From: Amanda Scholes on behalf of Planning.Responses
Sent: 07 December 2021 08:51
To: Planning Scanning
Subject: FW: BR/134/21/PL
Attachments: 3995-04b.pdf

From: Huw James
Sent: 01 December 2021 18:06
To: Maria Tomalova
Cc: Rebecca Hoad
Subject: RE: BR/134/21/PL

Site Plan
As Proposed
1:200

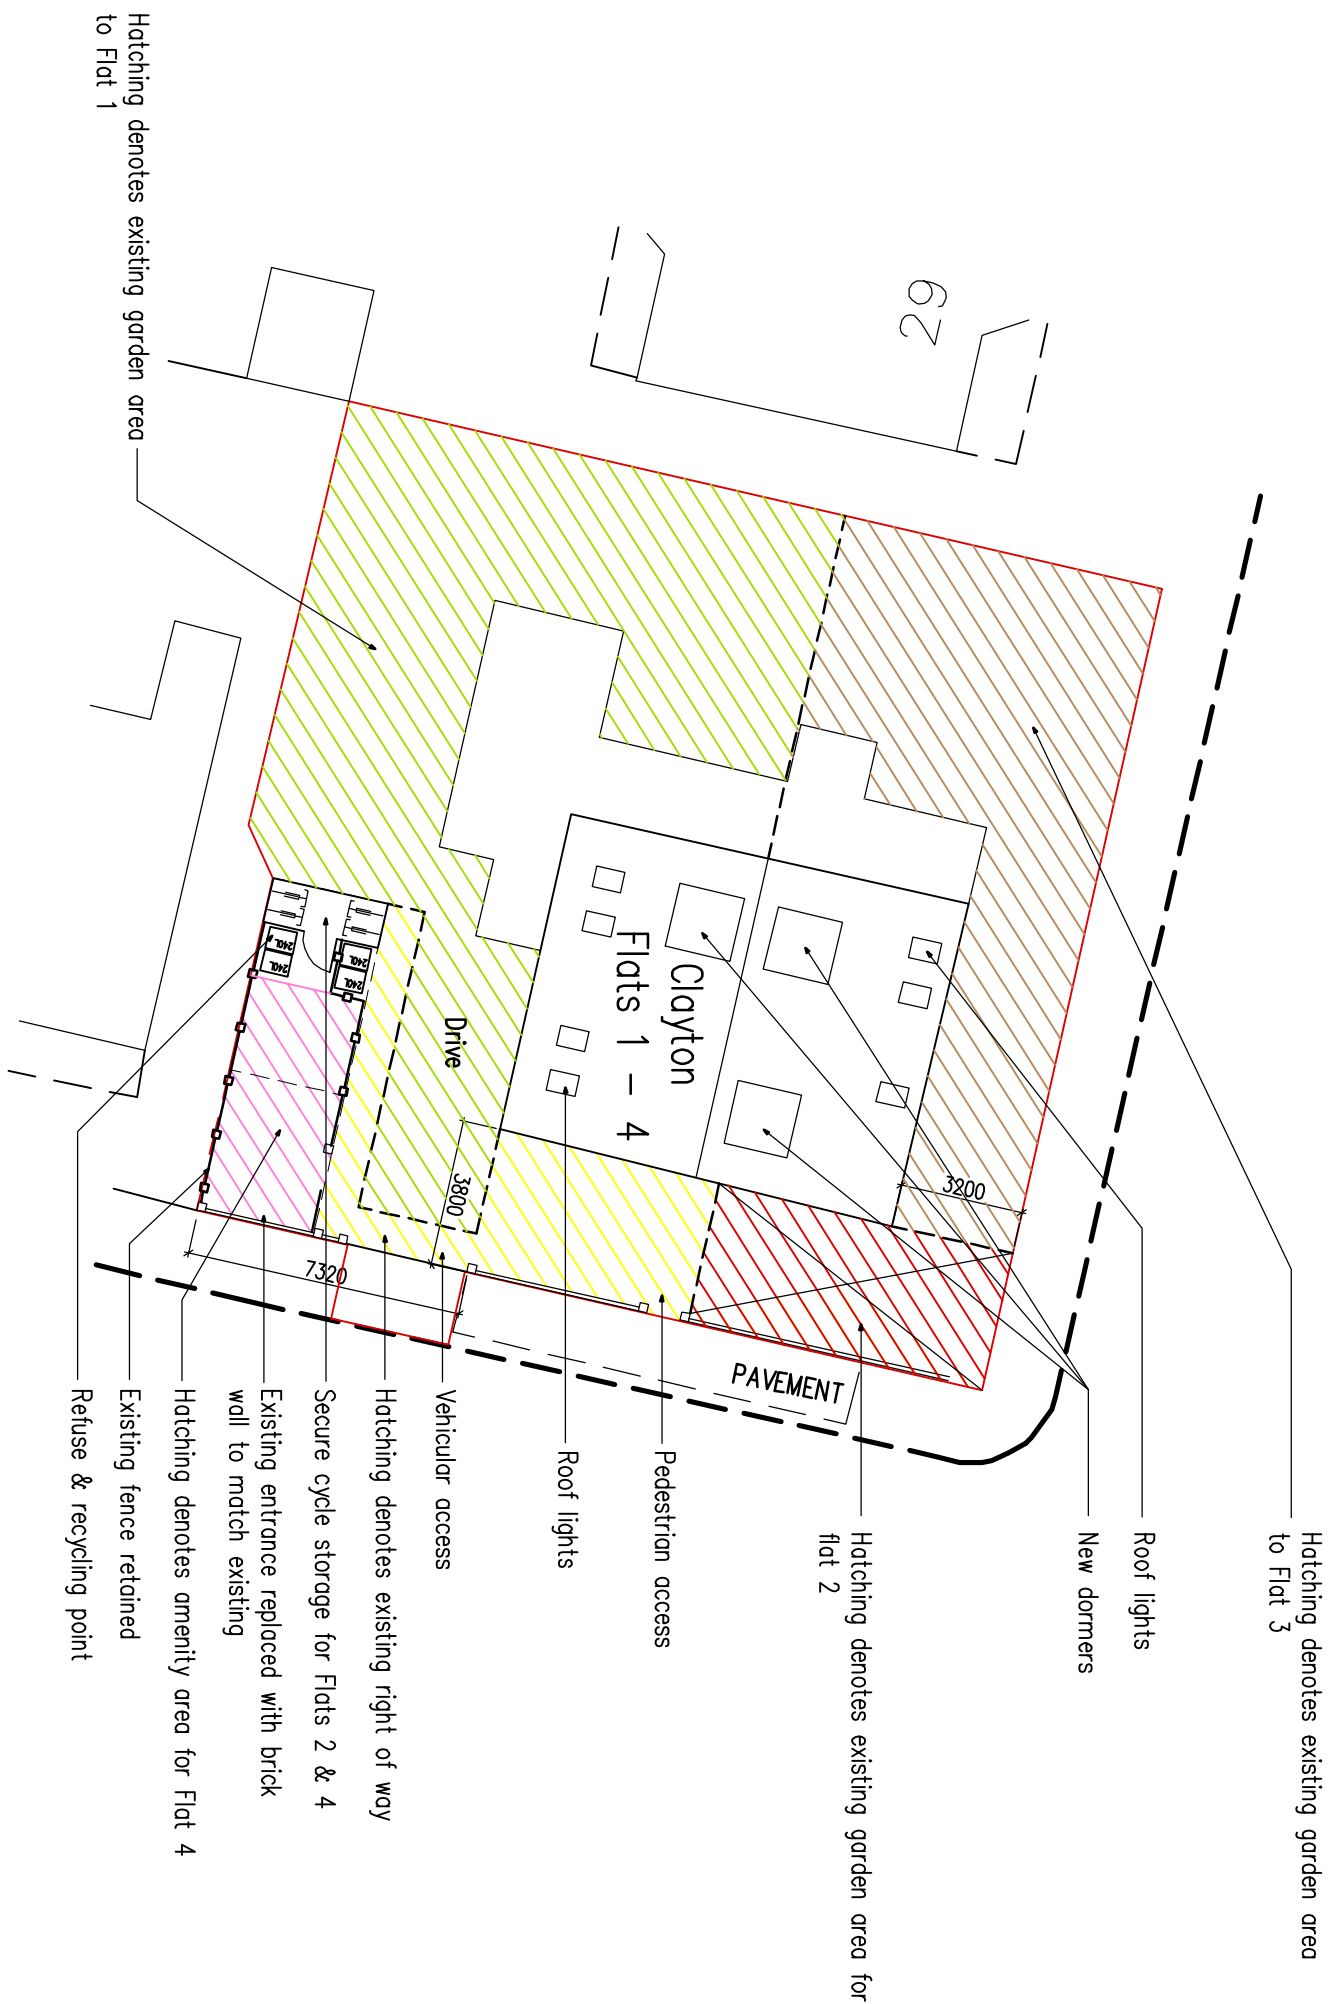
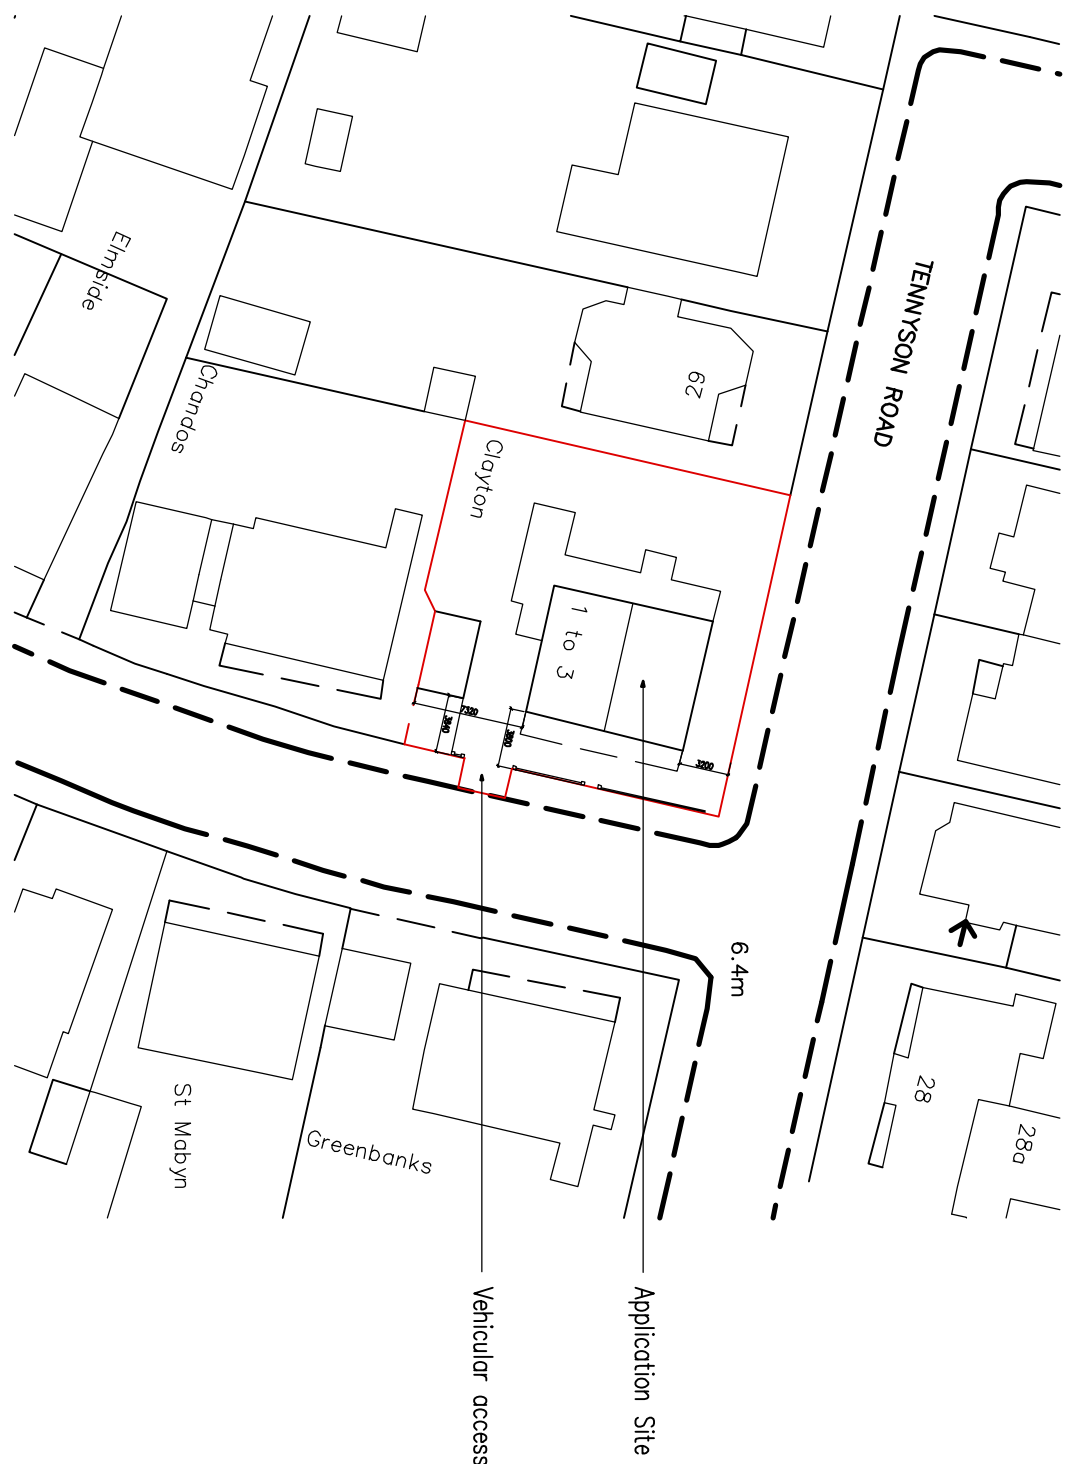
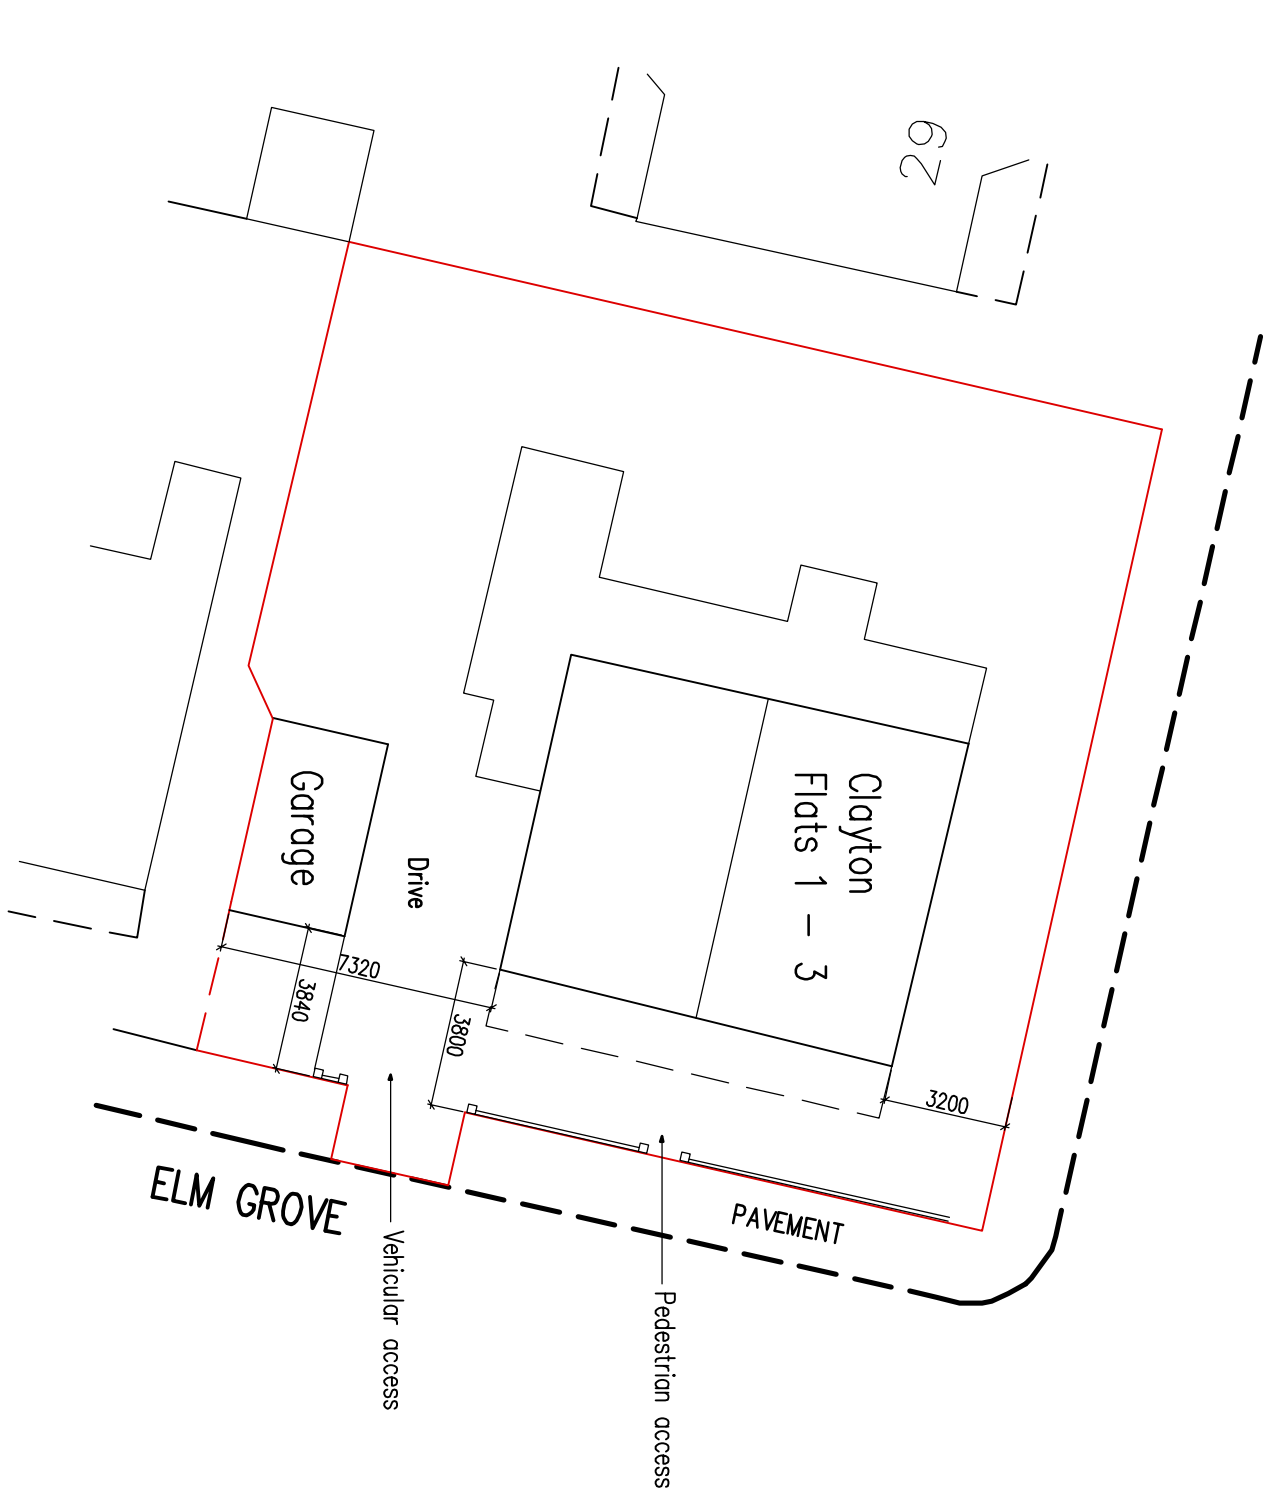
Arun Design Guide part H.04 advises on Residential Outdoor Amenity & External Space Standard:
- All development should provide residents with access to outdoor amenity space, whether private or communal. It advises that Residential Communal Shared Spaces should be minimum 40sqm plus 10sqm for each unit.

The size of the plot would allow for the required Residential Shared Communal Space, however, the allocation is provided unequally. In respect of external standards, the submitted drawings show allocated private space for proposed flat 1 of approximately 106 square metres, 93 square metres for flat 3 whilst the allocated private space for flat 2 is up to 30 square metres only. This should be re-considered.

I mentioned in my supporting email with the attached plan (9 November 2021) that the existing amenity areas for the other flats is shown on the plan but this is shown 'for information only'. The existing amenity areas for flats 1 to 3 do not form part of this application and are sold on long leases to their owners. Their gardens and amenity areas have been laid out in this way for many, many years and probably date back to when the property was first built and the freehold/leasehold was set out. We need to clarify that we cannot legally amend their gardens to more equally divide up the amenity space and should not be required to do so as these flats do not form part of the application.

We can only influence the amenity space for flat 4 (subject of this application) and the attached plan shows that the area of the existing garage (to be removed) and the land in front of it will be dedicated to this unit for amenity space. Refuse and cycle storage is also proposed (in the location where the garage would be removed) that can benefit both Flats 2 and 4 (the others have their own refuse/cycle storage spaces) and is accessed via the communal space (hatched in yellow).
